DOC20/626891

5 August 2020

**Sydney Metro Chatswood to Sydenham – Modification 8 –  
Blues Point Access Site (SSI 7400 Mod 8)  
EPA Advice on Modification**

Figure 7-2 Blues Point temporary site haulage routes (as identified in the Environmental Impact Statement)

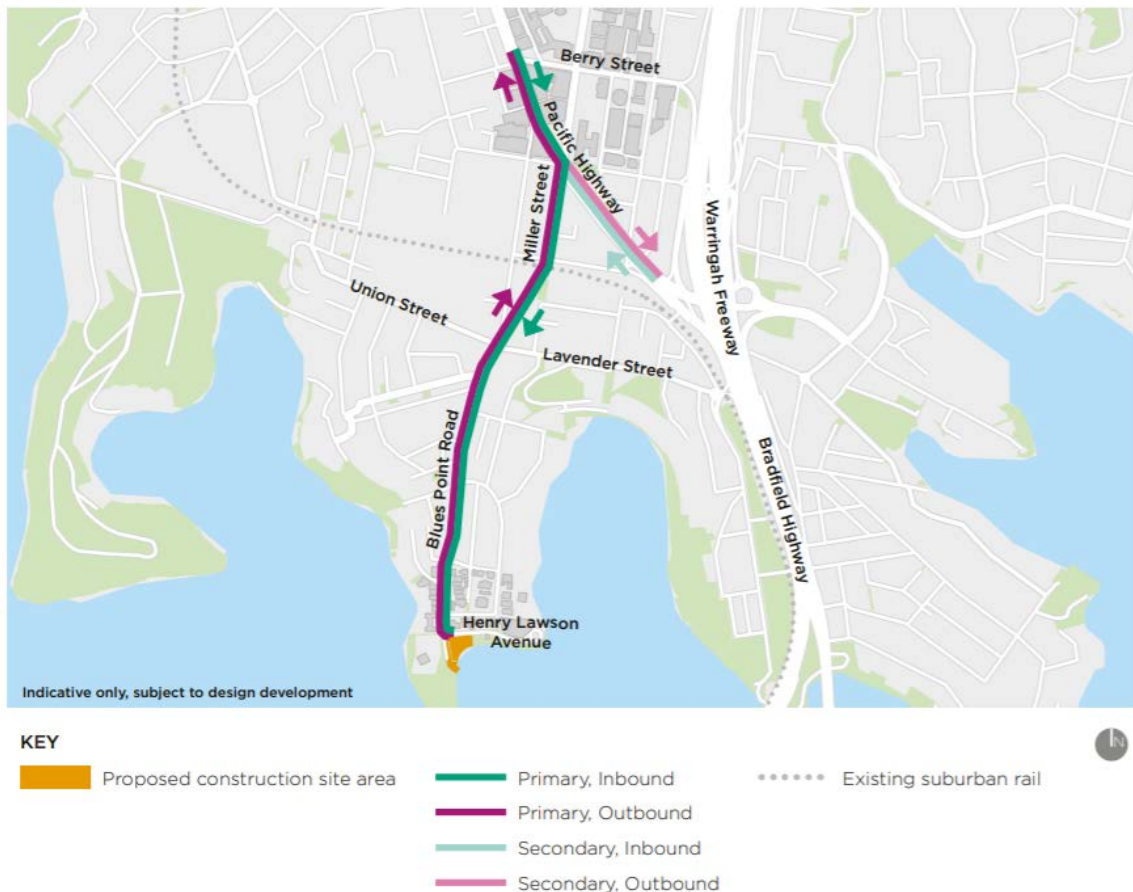
It is noted that conditions E84 and E85 required consideration of non-road transport options for spoil haulage etc. to minimise impacts associated with road transport. Consequently, barging activities from the Blues Point site were implemented by the TSE contractor. It is noted that barging is not proposed for this aspect of the proposal and that concrete and other material deliveries will be via local roads.

However, it should be noted that the traffic predictions in the EIS were not actually realised because alternative means for spoil haulage were identified and implemented. Off-site traffic impacts are managed via the planning approval and should be considered by DPIE in the modification determination. The EPA notes that the construction traffic assessment has essentially relied upon the assessment in the EIS and has not specifically considered the current proposal in the modification request.
